Office of Environment & Heritage

DOC16/362454-1
SSD 4974

RE: WALLARAH 2 COAL PROJECT – AMENDED DEVELOPMENT APPLICATION (SSD 4974)

ATTACHMENT 1: OEH REVIEW OF THE WALLARAH 2 COAL PROJECT – AMENDED DEVELOPMENT APPLICATION (SSD 4974)

Figure 2: Conceptual Project layout.

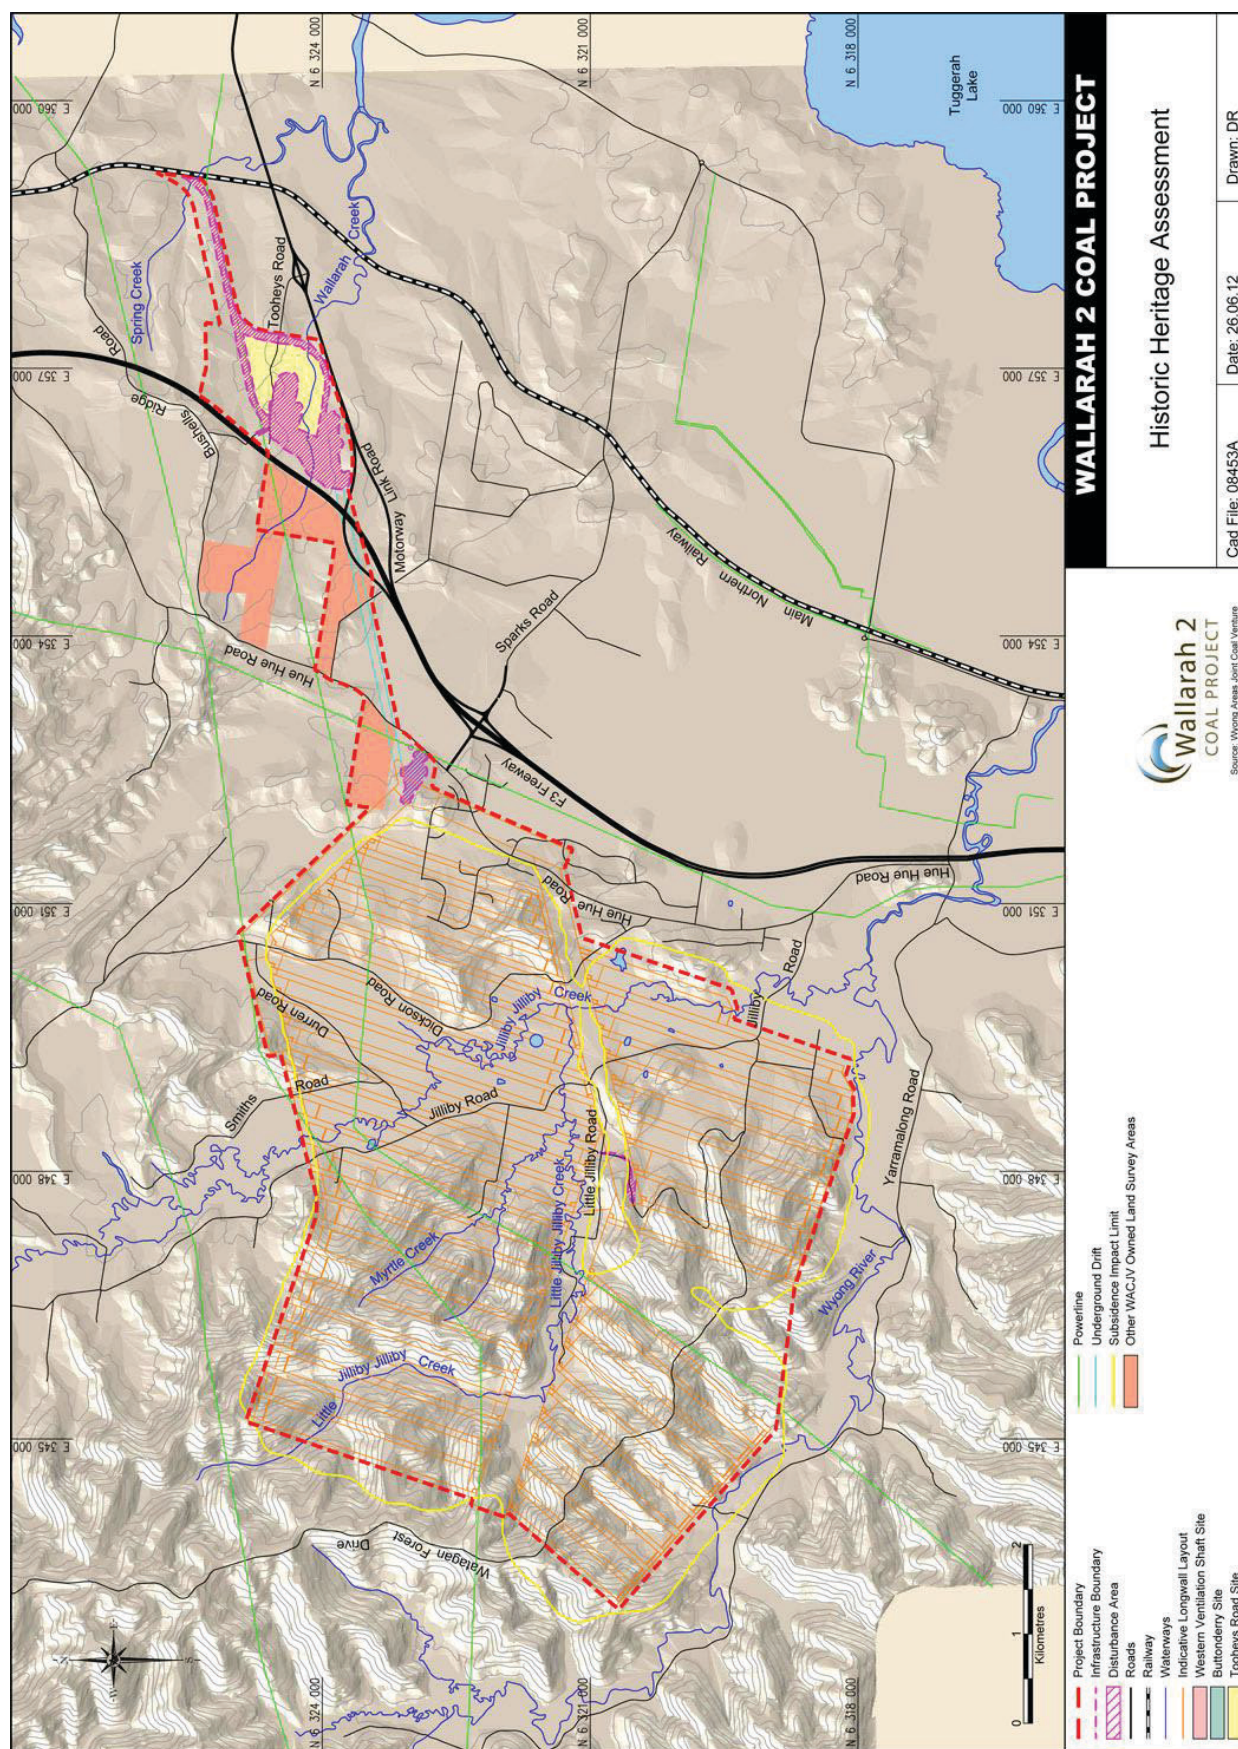
The new EIS has a map of the mine layout for the current DA (Figure 2 of the Main Report of the EIS) which includes 11 longwall panels in the far west of the project area that are identified as 'Potential Future Mining Areas'. These 11 longwall panels were part of the original mine plan when the first development application for the mine was lodged in 2006. However, during the assessment of this proposal the Planning Assessment Commission (PAC) (November, 2010), the PAC recommended against secondary extraction (i.e. longwall mining) under Jilliby SCA, at least not until after a comprehensive assessment of surface features and mine subsidence impacts and effects had been conducted to the satisfaction to the Director General of the Department of Planning and Environment (DPE). Further, the PAC recommended that any changes to the proposed mine layout would first require a comprehensive assessment to the satisfaction to the Director General of DPE.

While the proponent may seek a subsequent development application to undertake longwall mining in these western portions underlying Jilliby SCA, OEH requests that longwalls not be shown in the 'Future Mining Areas' section of the map because:

- (a) there is no certainty that these longwalls will be approved in the future;
- (b) if longwalls are proposed in the future, their dimensions and location may be different; and
- (c) OEH notes the position taken by DPE that should mining proceed in the western section, sensitive areas need to be avoided.

Given this position, OEH believes that the location of the unapproved longwalls should not be shown and that only the 'boundary' of the area intended for further development should be indicated.
